**KIRKLEES METROPOLITAN COUNCIL
INVESTMENT & REGENERATION SERVICE**

**DELEGATED DECISION TO DETERMINE APPLICATIONS FOR
CONSENT, AGREEMENT OR APPROVAL REQUIRED BY CONDITION**

Reference No:	2024/44/92016/E
Site Address:	Land Adjacent, The Shears, 201, Halifax Road, Hightown, Liversedge, WF15 6NR
Description:	Discharge of details reserved by conditions 5 (materials), 6 (boundary treatment), 7 (Phase I Desk Top Study), 12 (bin storage/locations), 13 (evc) on previous permission 2023/93657 for erection of two detached dwellings with detached garages; alterations to public house with dwelling above to form one dwelling; erection of single and two storey extension to 201a Halifax Road
Recommending Officer:	Nicole Helliwell

DECISION – Discharge of Conditions - Approved

Drawing
Boundary Treatments, Bin Storage & Car Charge Locations

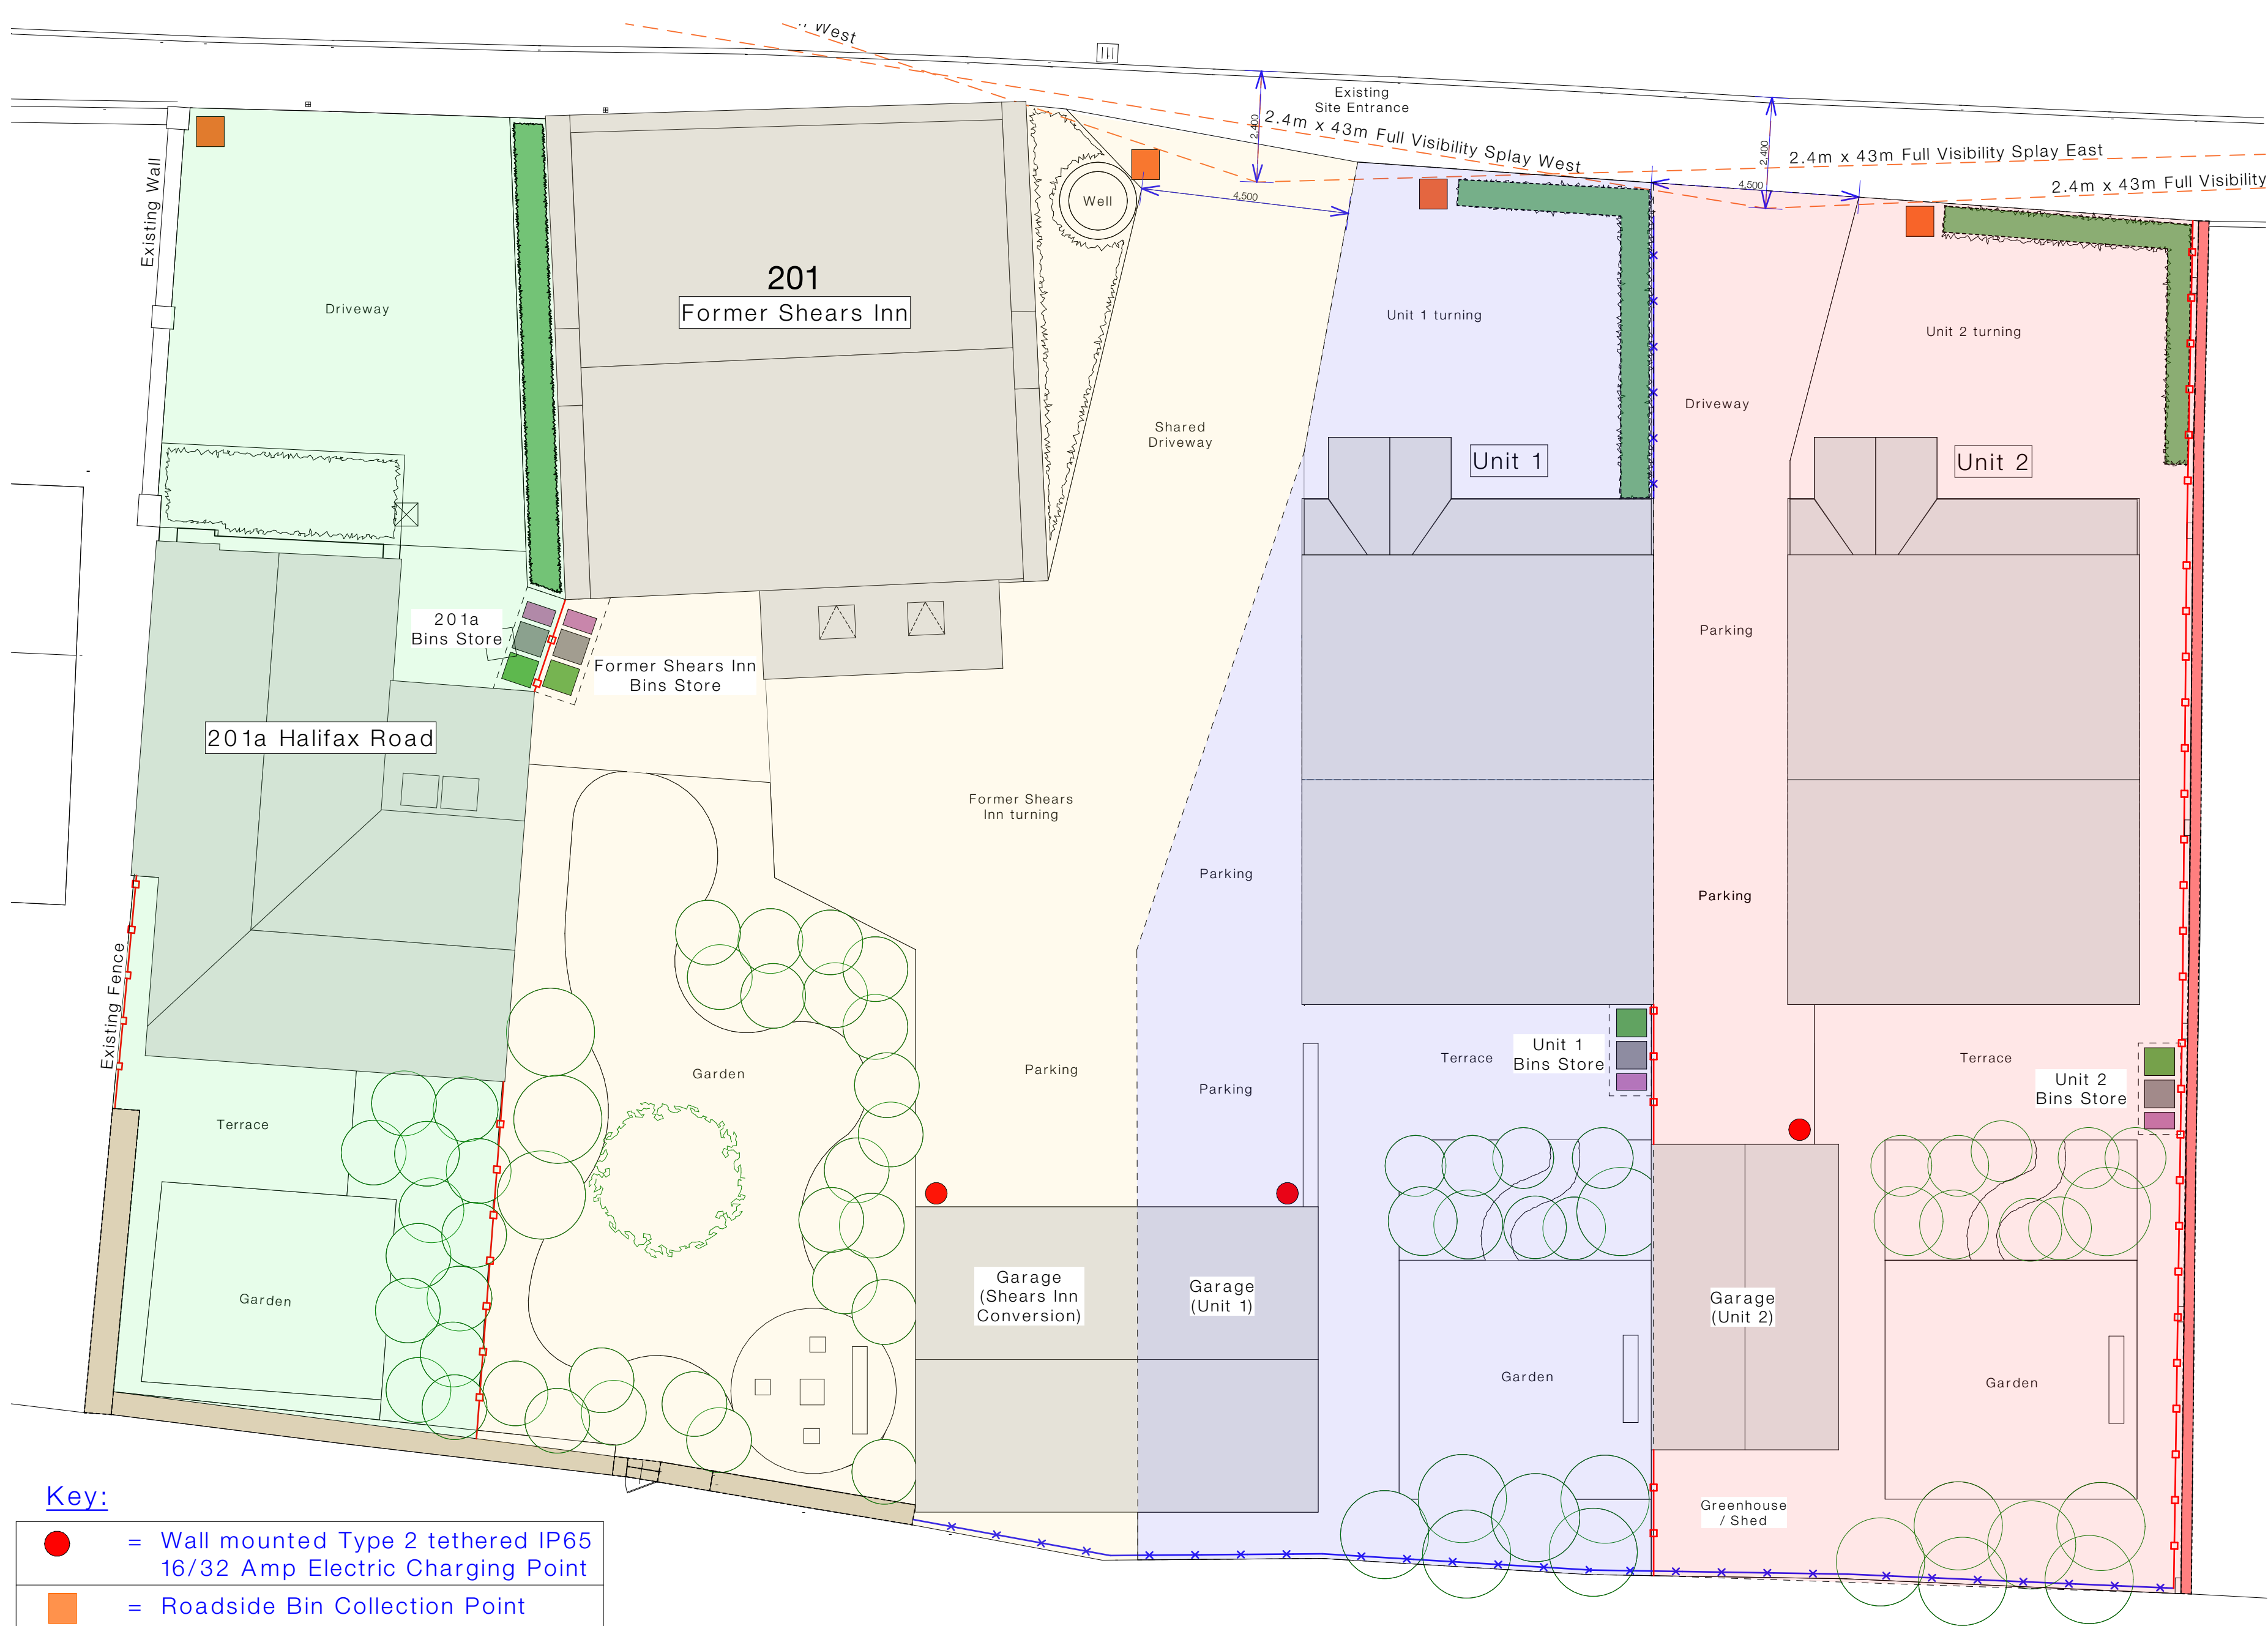
The applicant has submitted a document titled 'Boundary Treatments, Bin Storage & Car Charge Locations' (reference no. 3571(0-)15 rev. B, dated July 2024) which details the location, height and materials of the proposed boundary treatments. The proposed boundary treatments would comprise a 1m estate fence along the southern boundary of the site, a 1.8m timber vertical boarded fence along the eastern boundaries of unit 1 and 2 and a 1m low shrub/hedge would be planted along the northern boundary of units 1 and 2. The proposed boundary treatments would not cause any significant harm to visual or residential amenity. Therefore, these details are deemed to be acceptable for the purposes of the condition and therefore condition 6 can be discharged. This is subject to the hereby approved boundary treatments being completed in accordance with the approved details and thereafter retained.

The applicant has submitted a document titled 'Boundary Treatments, Bin Storage & Car Charge Locations' (reference no. 3571(0-)15 rev. B, dated July 2024) to support the discharge of condition 12. KC Highways have reviewed the drawing and have confirmed that the plan identifies suitable locations for the bin storage and collection points. As such, condition 12 can be discharged.

The applicant has submitted a document titled 'Boundary Treatments, Bin Storage & Car Charge Locations' (reference no. 3571(0-)15 rev. B, dated July 2024) to support the discharge of condition 13. The plan proposes the installation of 1x wall mounted Type 2 32kw EVCP at each dwelling. The information above is acknowledged and accepted, however as the EVCPs have not yet been installed and need to be retained to comply with the condition, KC Environmental Health recommend that the condition therefore remains in perpetuity.

In conclusion, it is considered that the proposed boundary treatment details are acceptable for the purposes of condition 6. However, condition 6 can only be fully discharged when the boundary treatments are constructed and maintained in accordance with the details approved.

It is considered that the submitted details are acceptable for the purposes of discharging condition 12.

KC Environmental Health accept the information provided and recommend the discharge of condition 13. However, the applicant is reminded that the EV units must be installed and fully operational prior to occupation and retained thereafter. Furthermore, approval under Building Regulations may be required.
